Subject: B-1 Design Review – 23 Ocean Avenue

Written by: Caitlin Cameron, Urban Designer

Date of Review: Wednesday, September 28, 2016

FLOOR PLANS

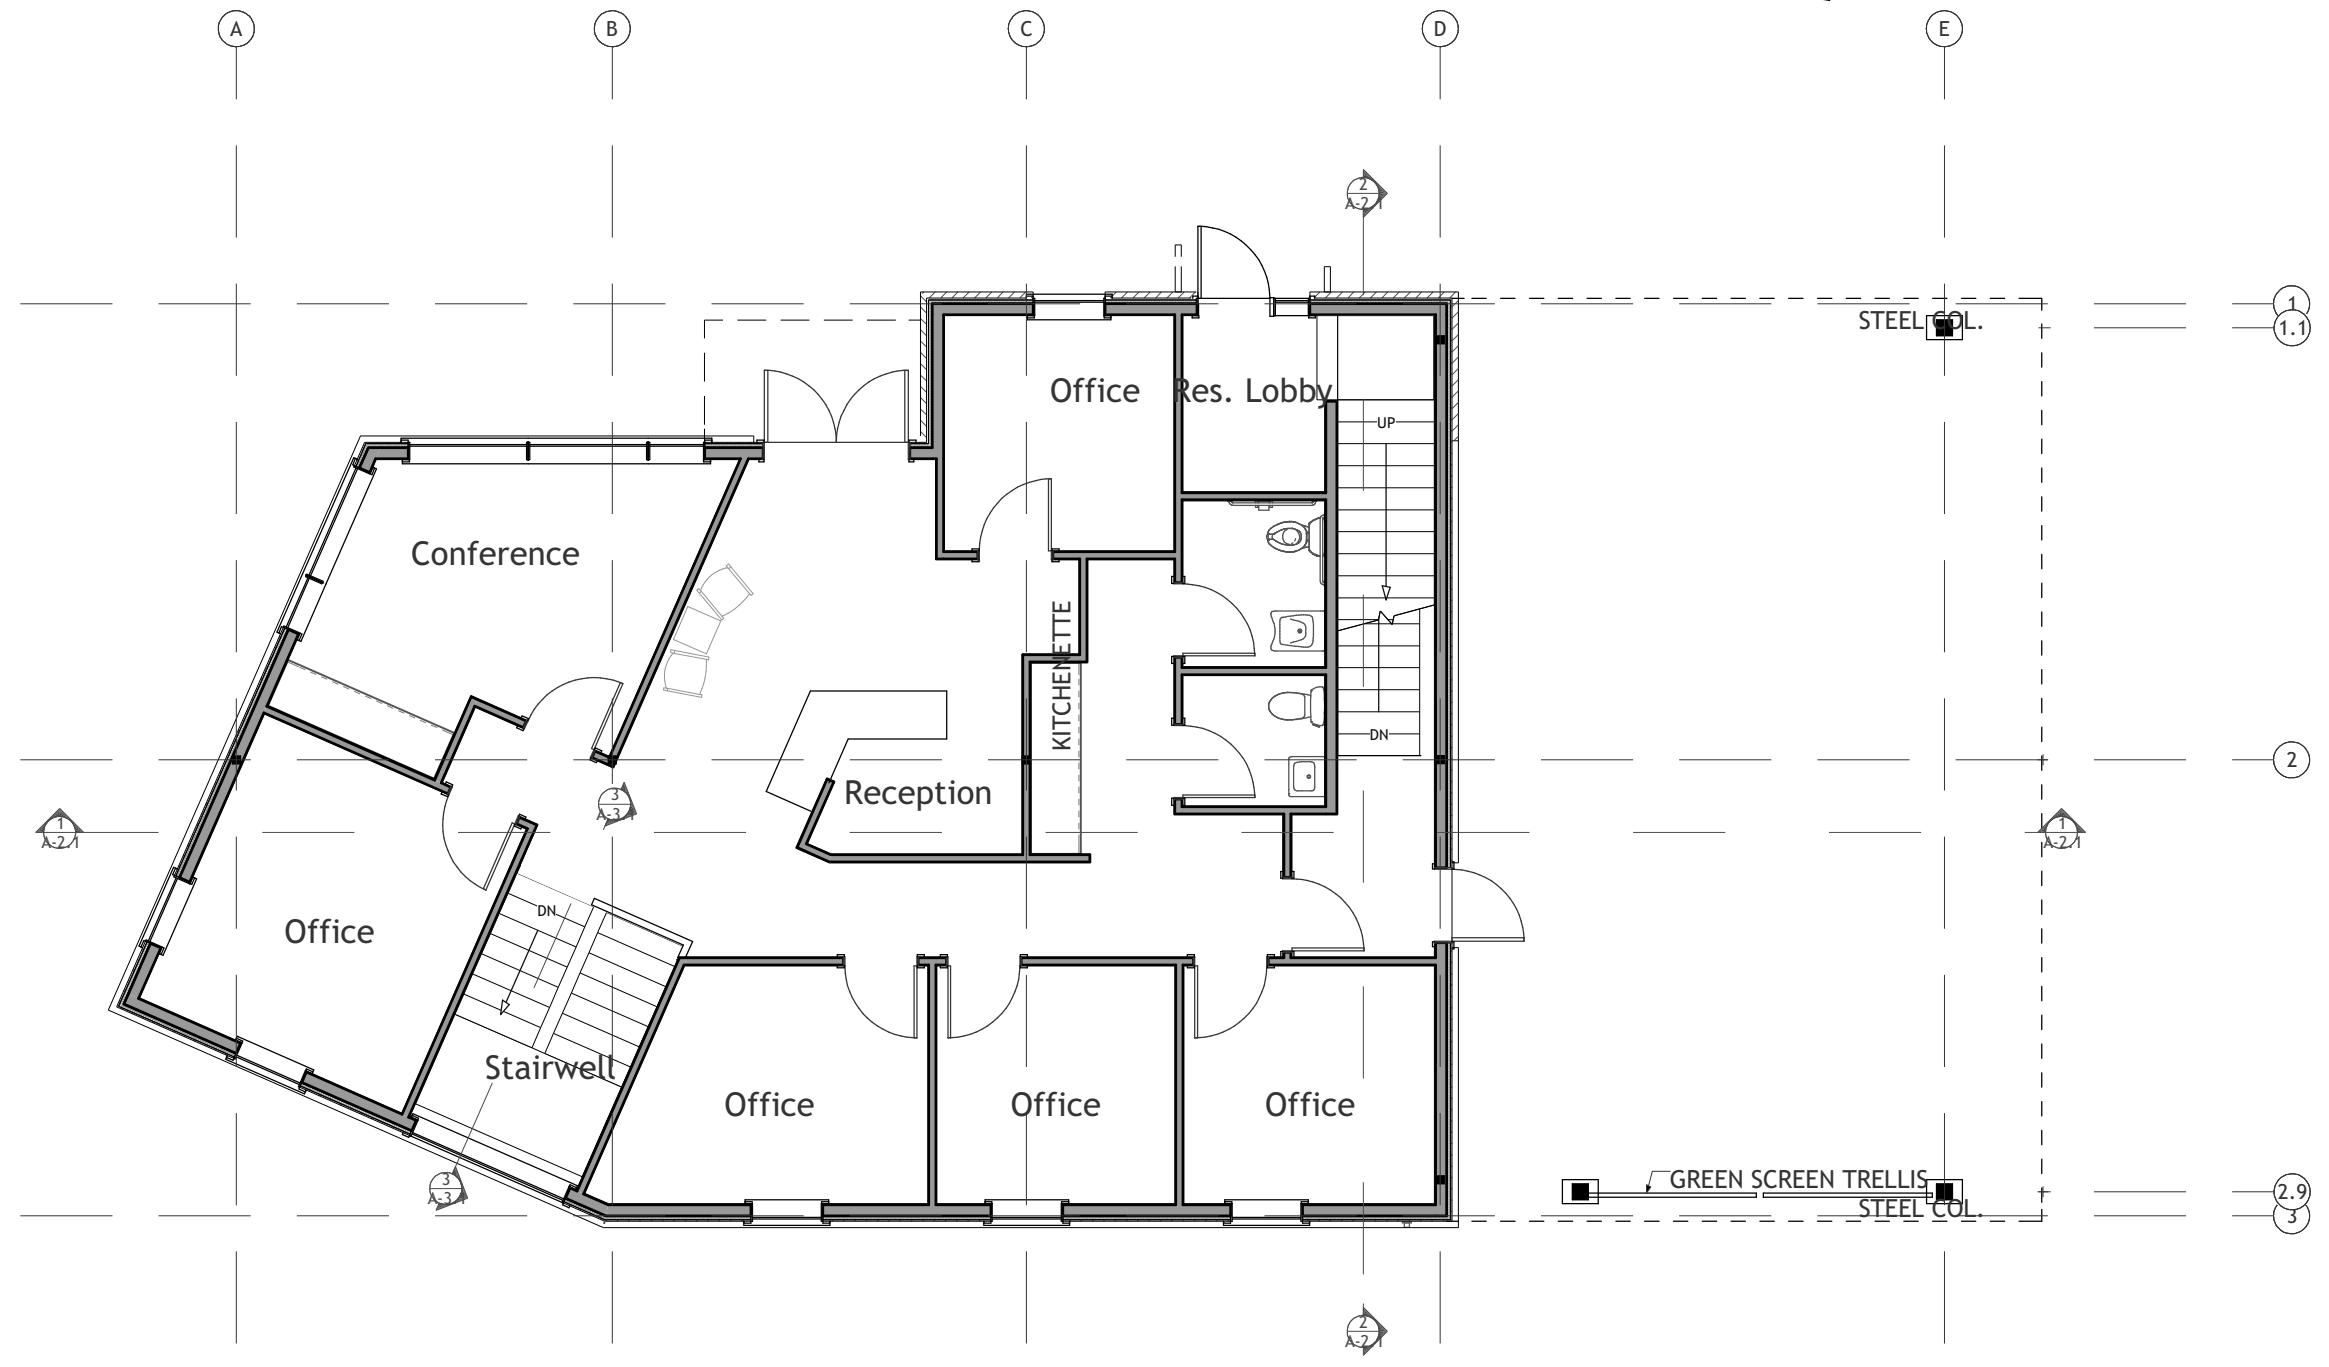
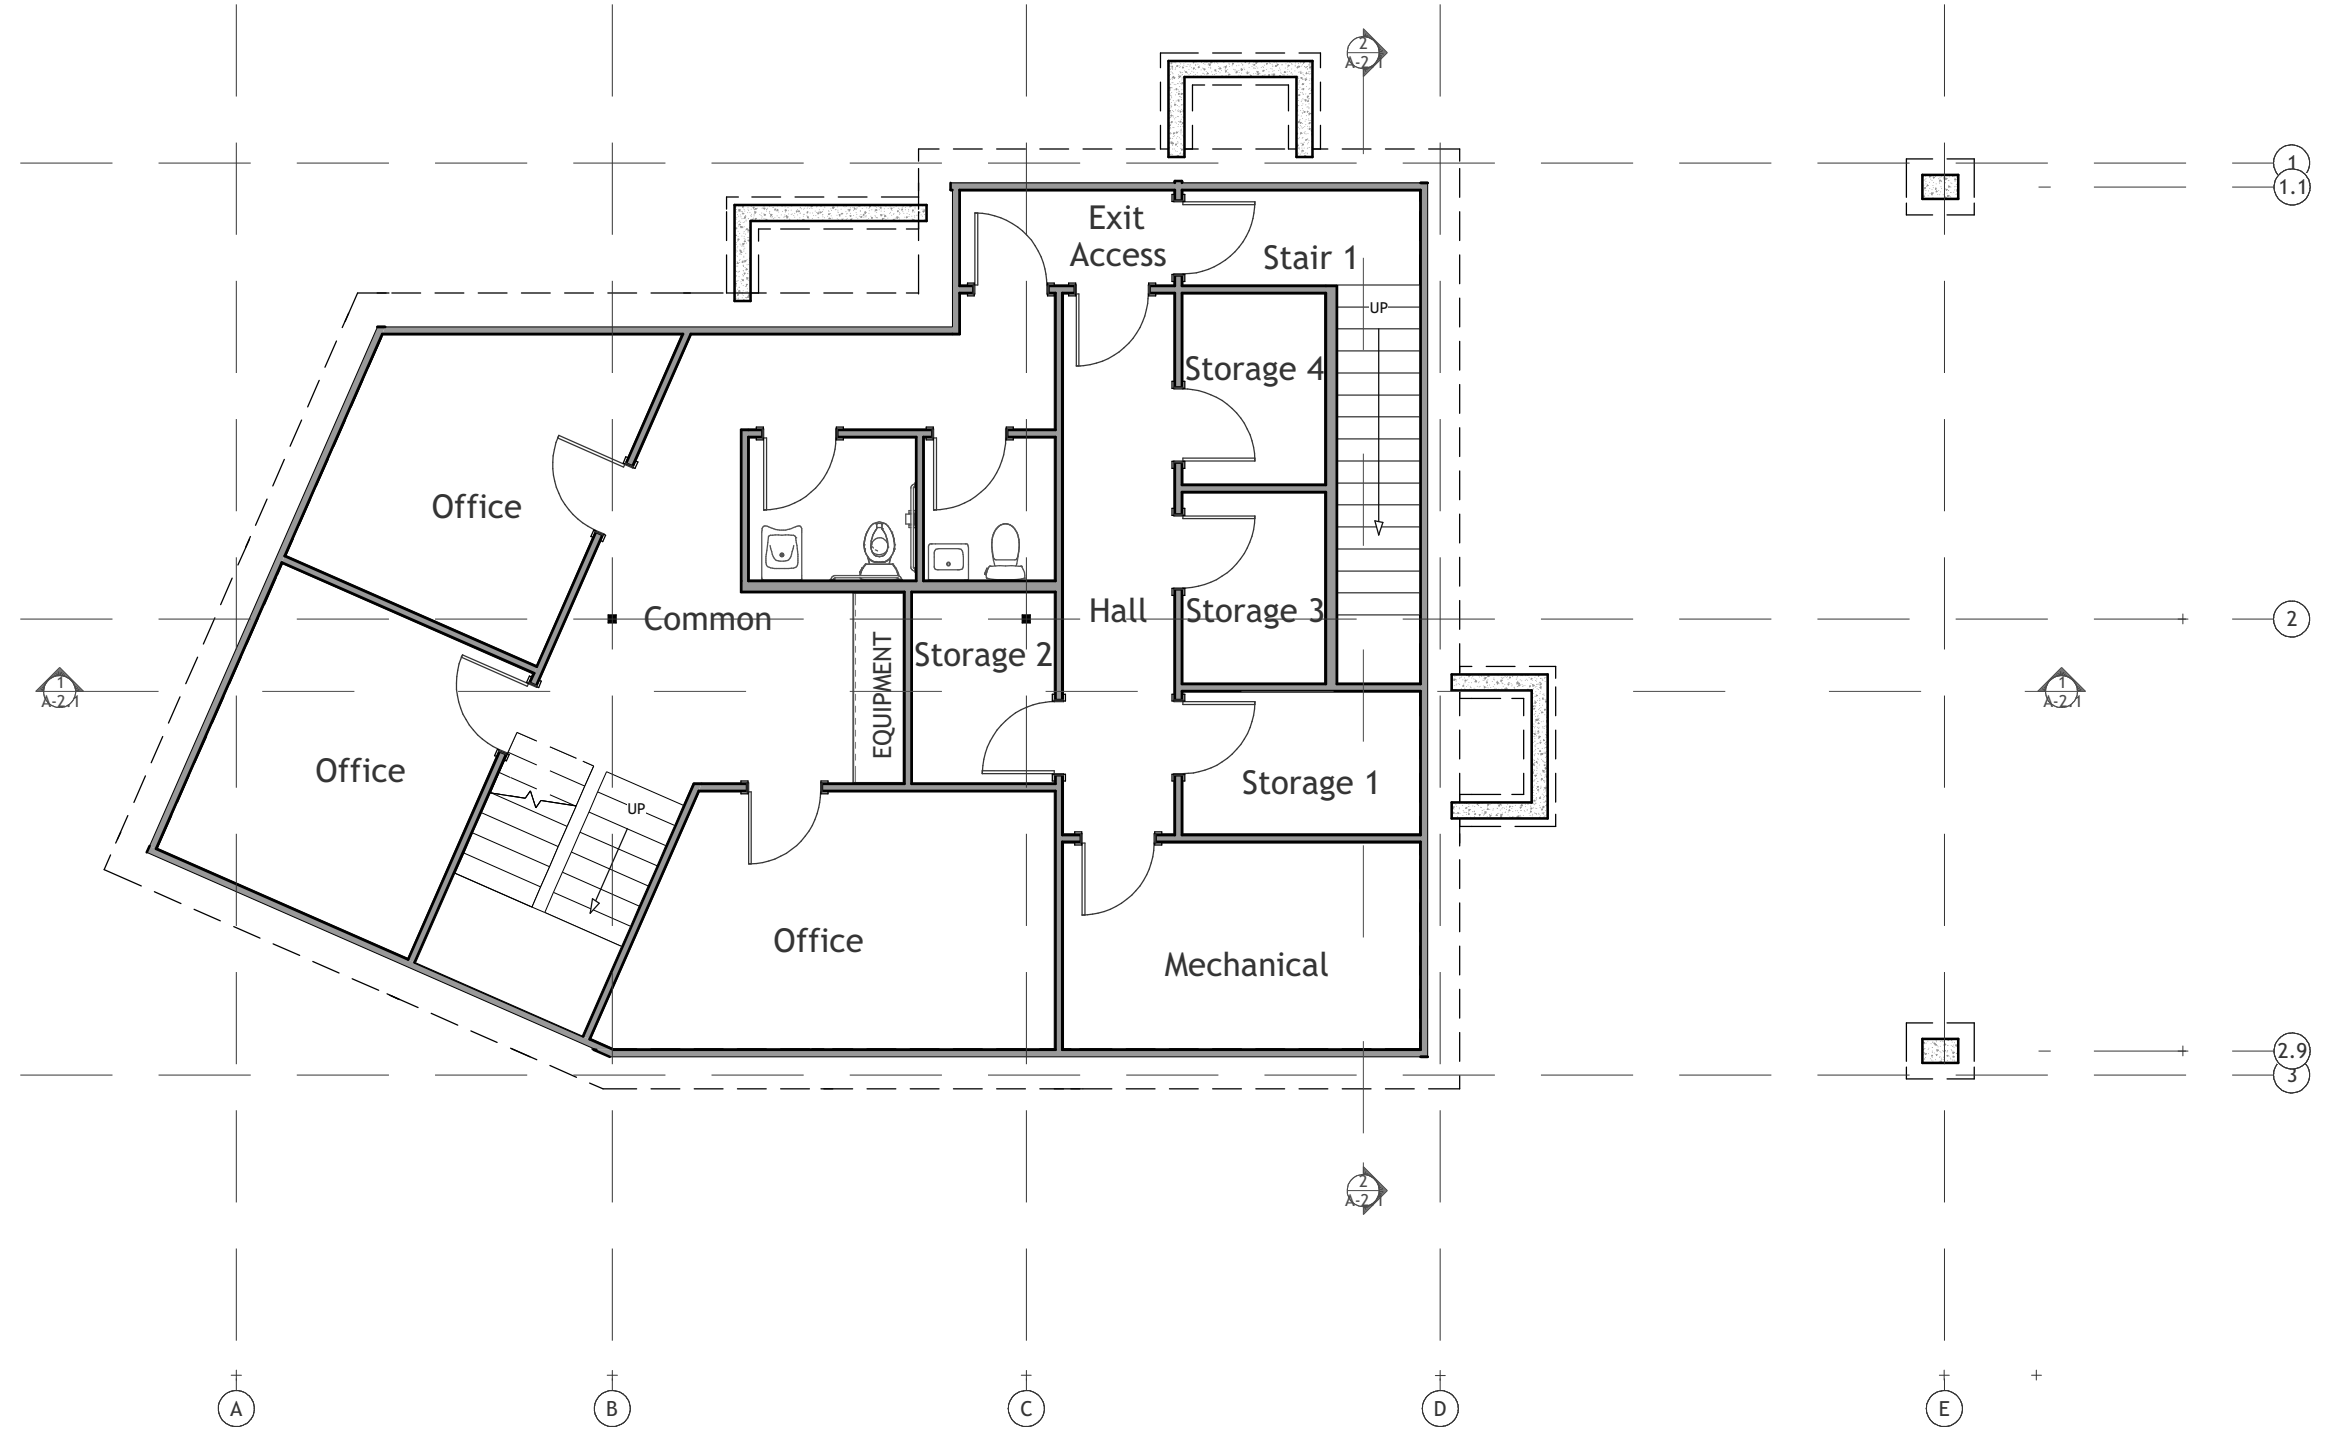
Standard (1) c. Building Entrances – Met - Principal office and residential entrances are side-facing but accessible from both sidewalks as required by the standard. The applicant was asked to add stronger visual cues to indicate the entrances, especially from the corner approach and indicating ADA route – the applicant added canopies and revised the materials of the ground floor to reflect its commercial use. Staff asked applicant to explore whether office entrance could be moved to face street or corner; applicant found this to be infeasible.

**A-2.2**

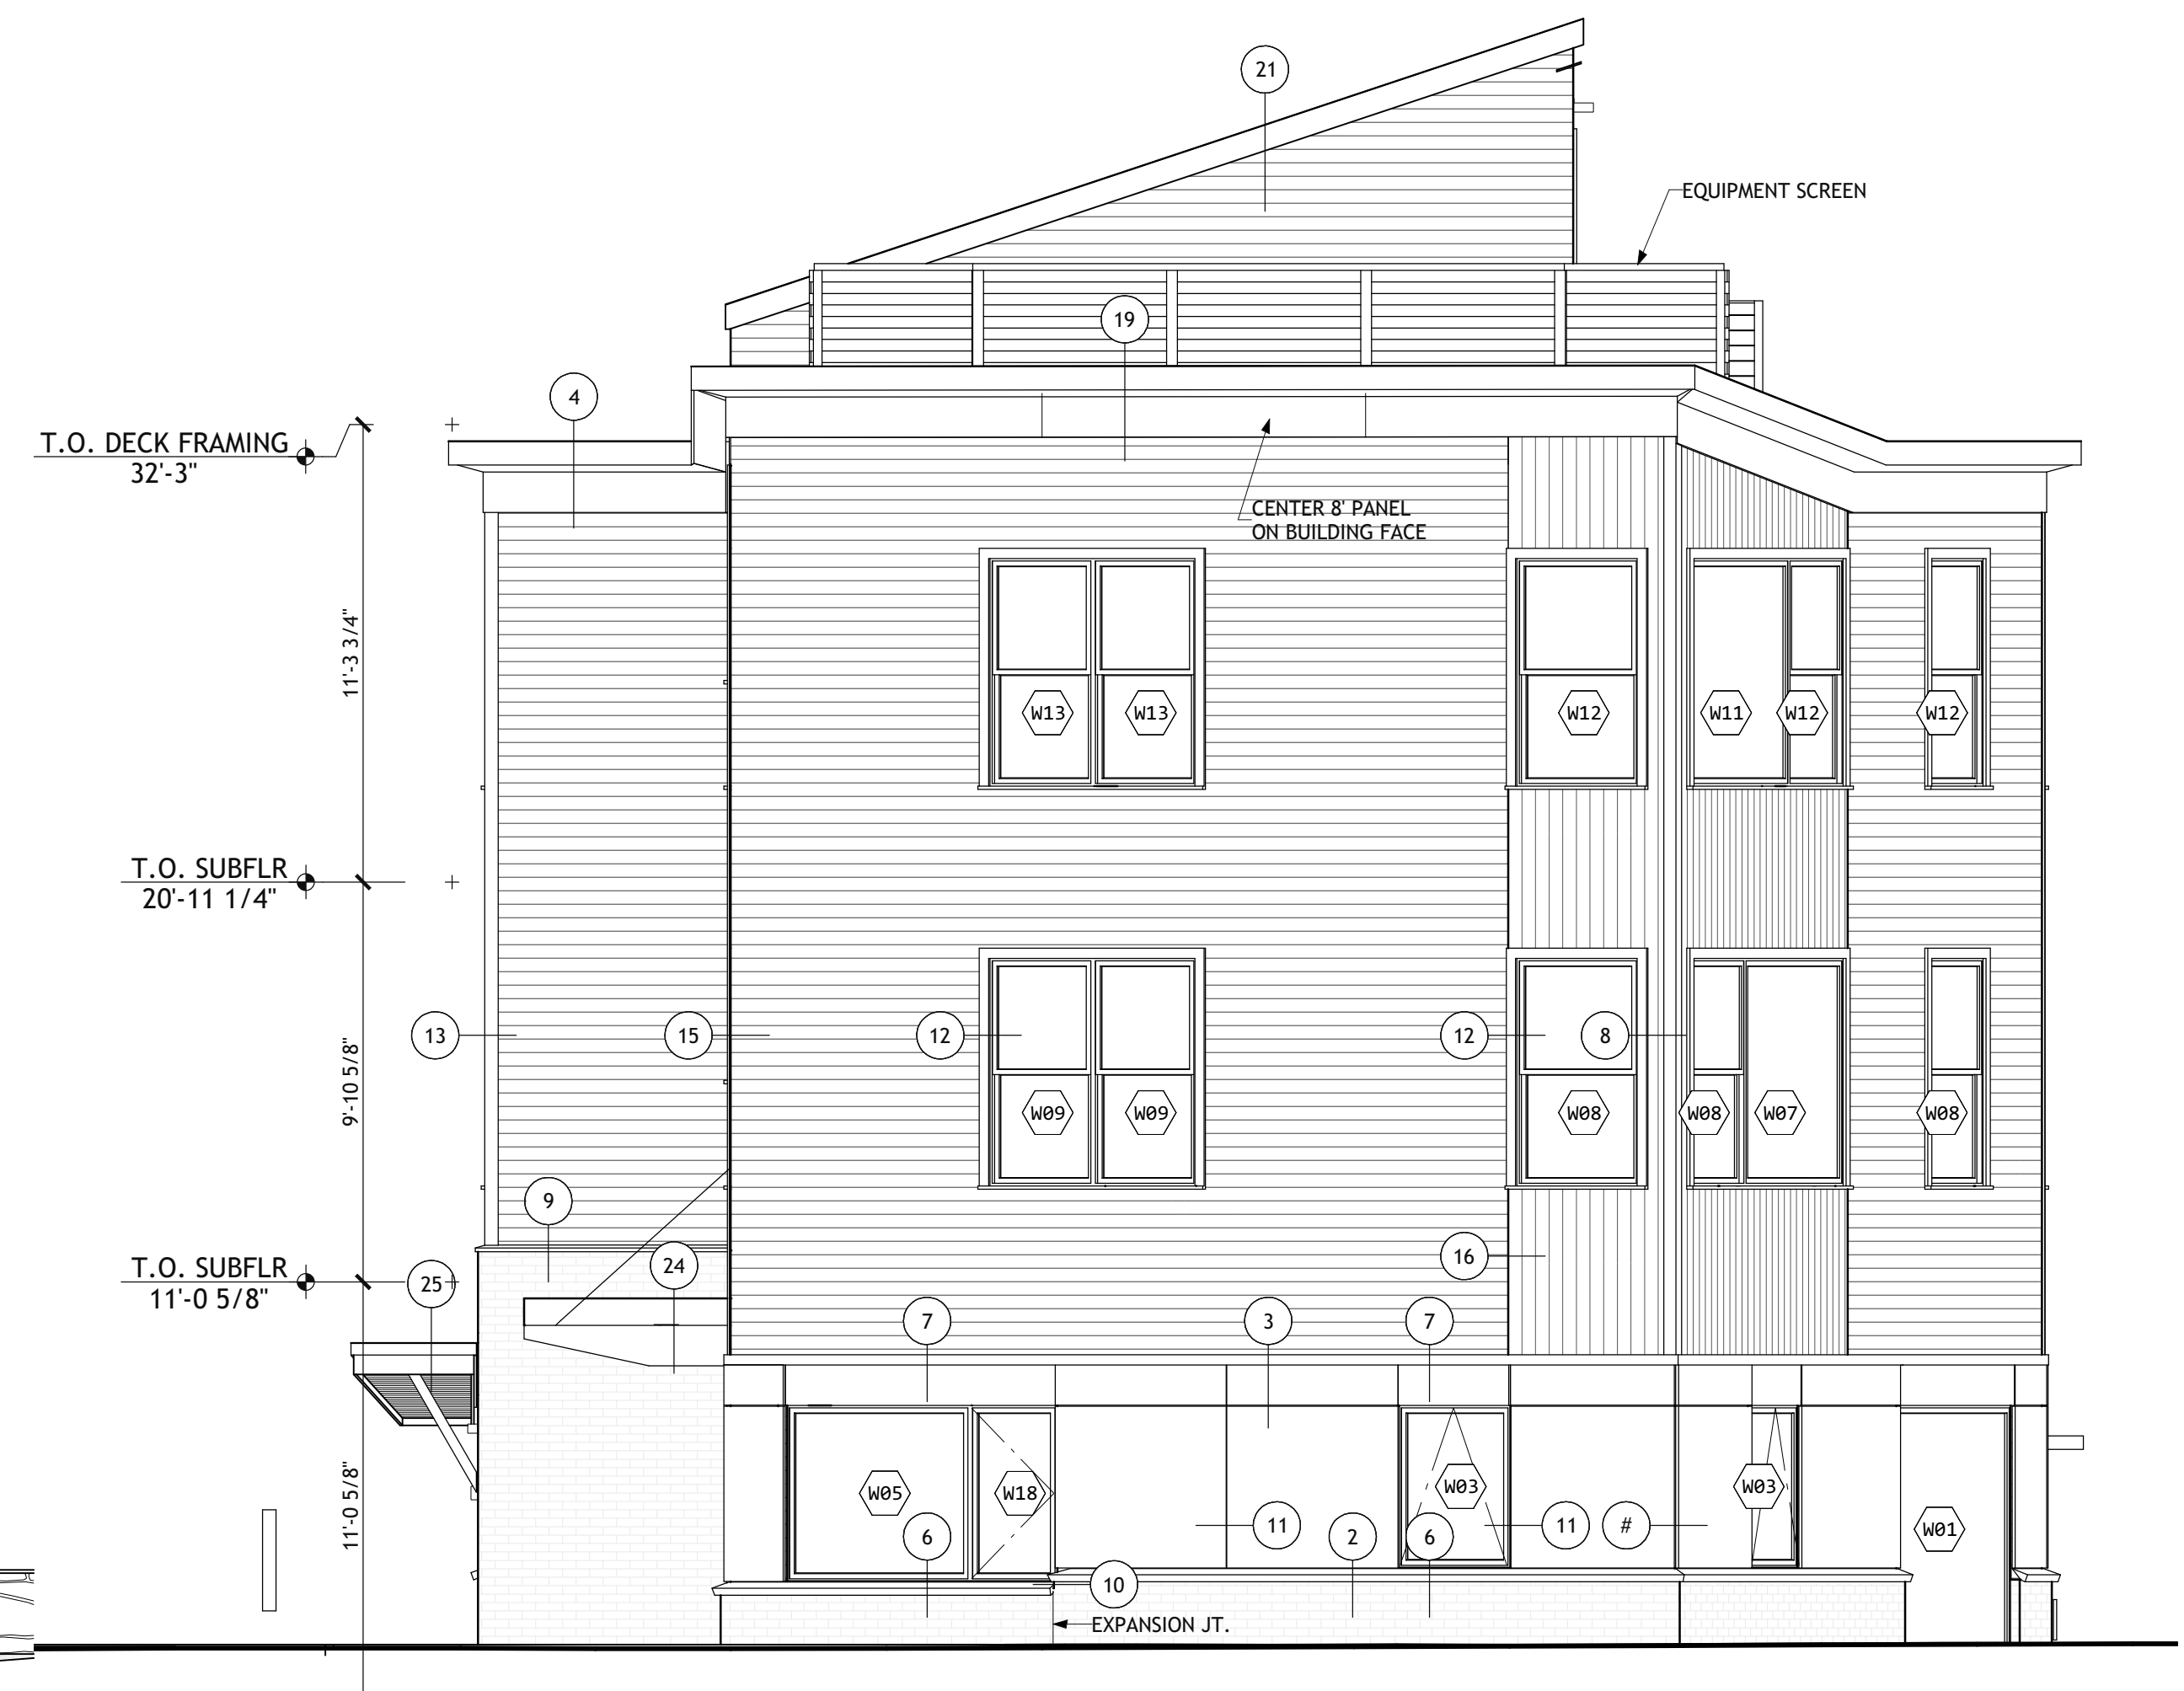
Standard (1) d. Windows – Met - The upper story windows were modified to align as requested to distinguish the residential from the commercial use and reflect residential patterns found in the context. The project uses office windows at the street corner with a picture window at the ornamental stair – these provide some indication of activity. The most active windows are placed interior to the block as an approach to the office entrance.

Standard (1) e. Façade Character – The commercial office use is placed adjacent to public sidewalk. Staff requested the ground floor façade character at the corner be made more active with a stronger orientation to the street. The applicant chose to modify the materials and roof line to emphasize the corner but fenestration was not revised. The more active office-front and entrance begin down the street and wrap the building corner interior to the block.

Standard (1) f. Building Design – Met - The proposed building is in a transitional parcel between residential and commercial zones and the context, even the residential streets, varies in massing, scale, and roof line. Overall, the building design is contemporary but compatible with

the surrounding context in its character, scale, and roof pitch. The portion of the building adjacent to the residential neighborhood continues to have clapboard materials and a three-story scale, a flat roof, and regular fenestration patterns using rectangular, vertically proportioned windows. As the building reaches the corner, the roof line and materials were revised to angle and provide emphasis at the more commercial corner approach.

Standard (1) g. Building Materials – Met - Materials at the ground floor include brick and fiber cement panel (a recent revision to differentiate the commercial ground floor use from the residential above). The upper floors remain metal cladding but metal is a fine-grain scale similar to clapboard with a matte finish. The materials in Woodfords is eclectic, though metal cladding is not common. The residential buildings in the context are predominantly clapboard with the occasional shingle. The metal proposed will be similar to clapboard in appearance. The applicant preferred metal for its durability and maintenance.
